STATE OF NORTH CAROLINA
DEPARTMENT OF TRANSPORTATION

Addendum No. 1

RE: Contract # C204562

11 SECTIONS OF SECONDARY ROADS.

5

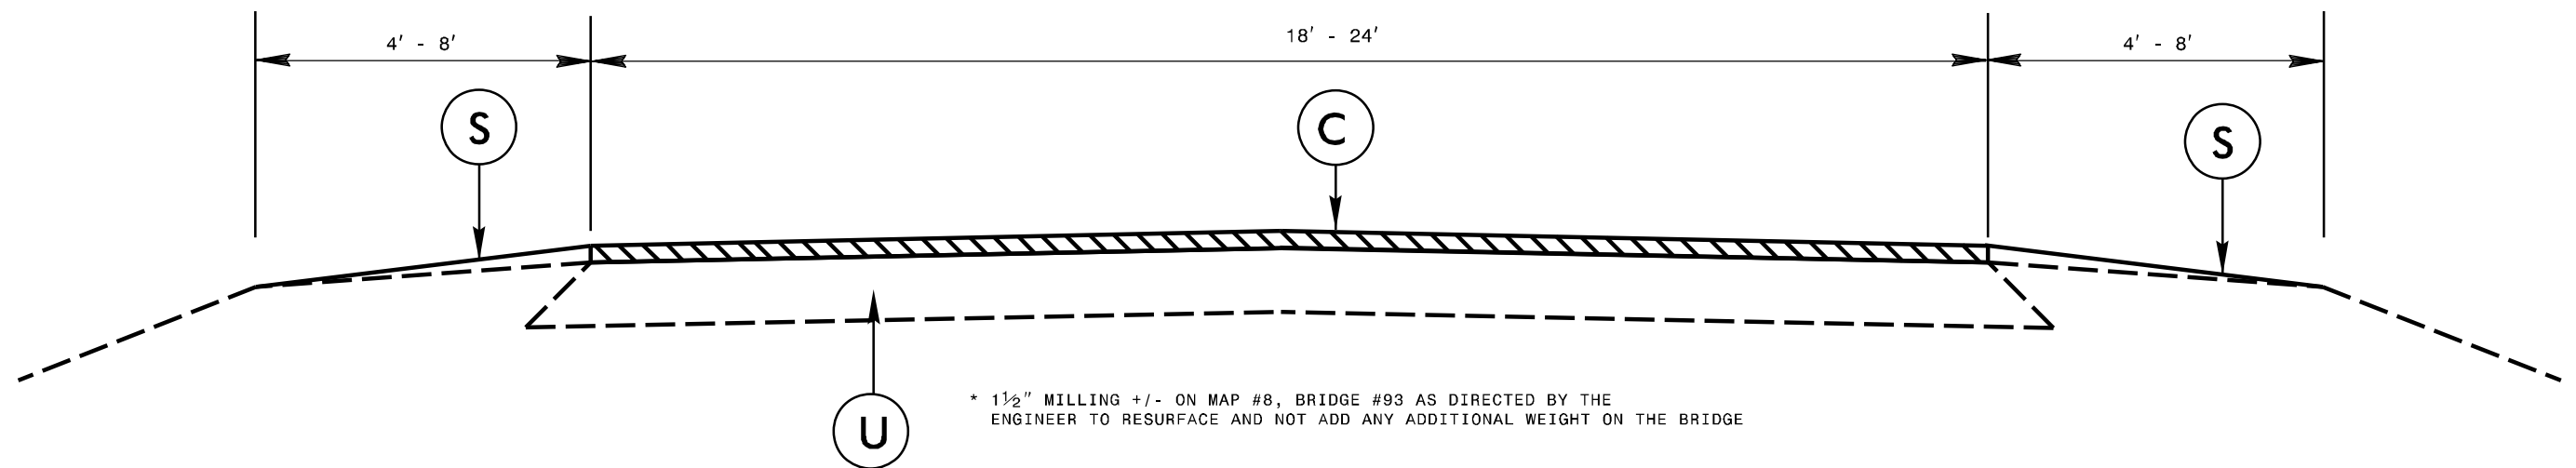
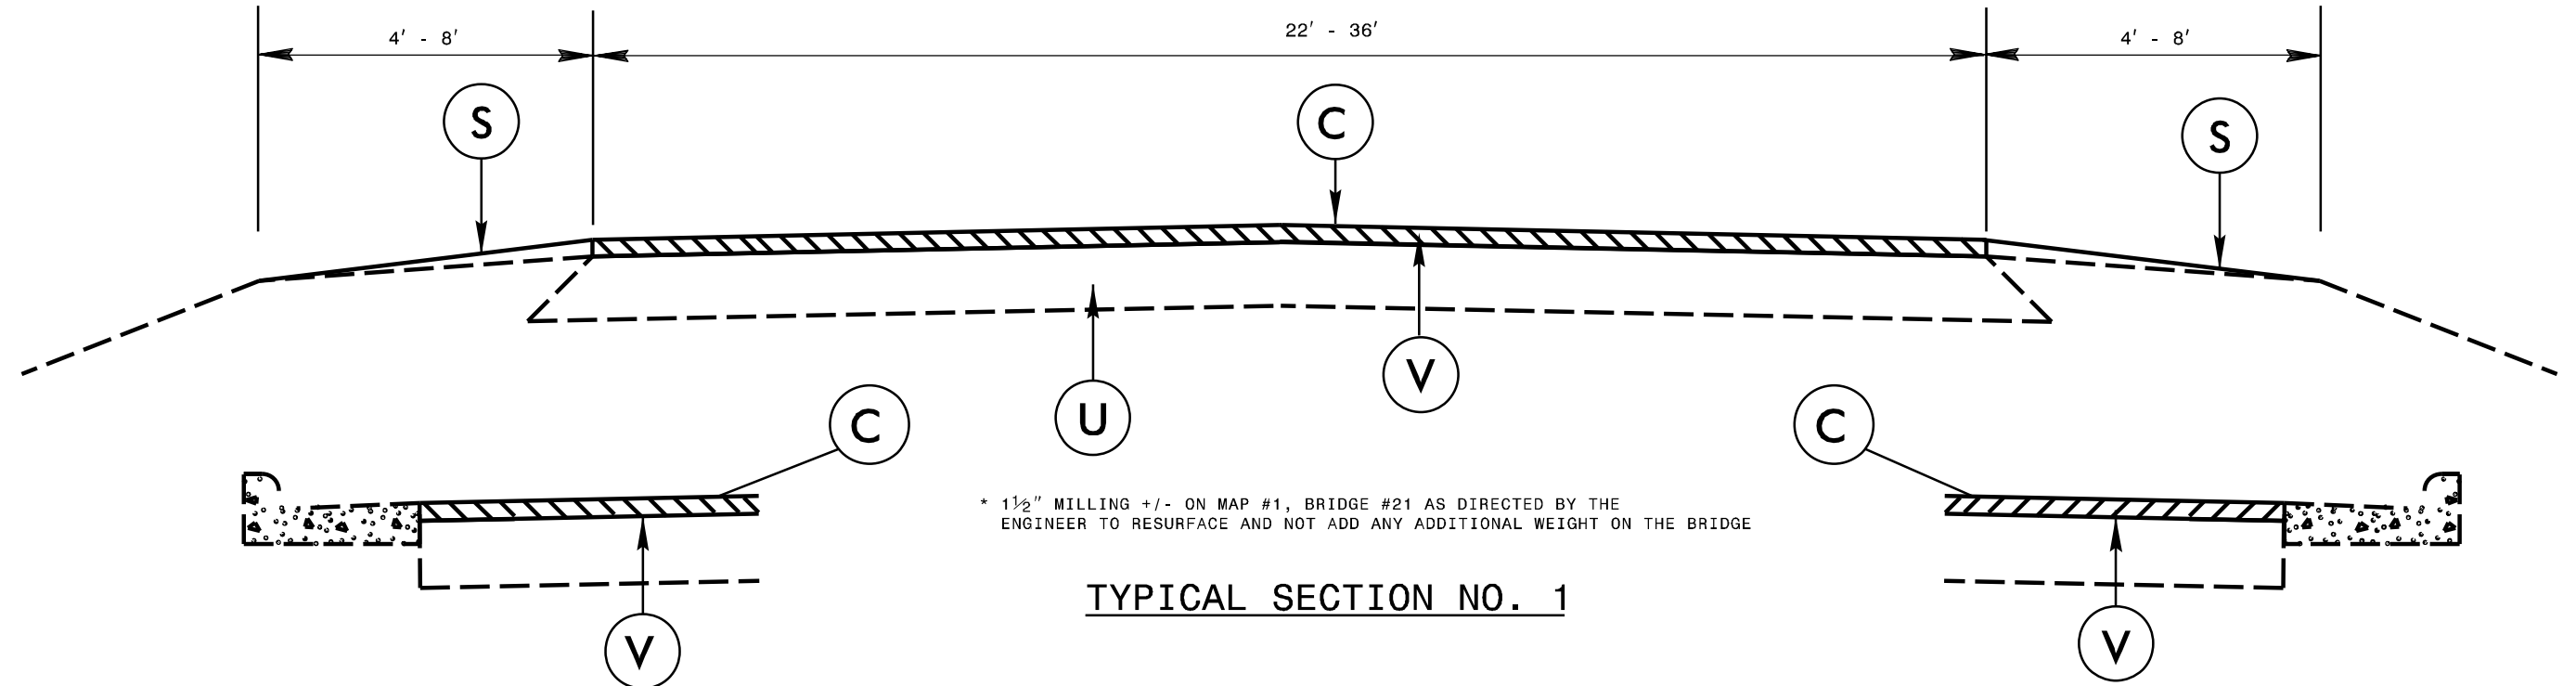
| Sheet No. | Revision |
|-----------|-----------------------------------|
| 5 | 2 notes added to Typical Sections |
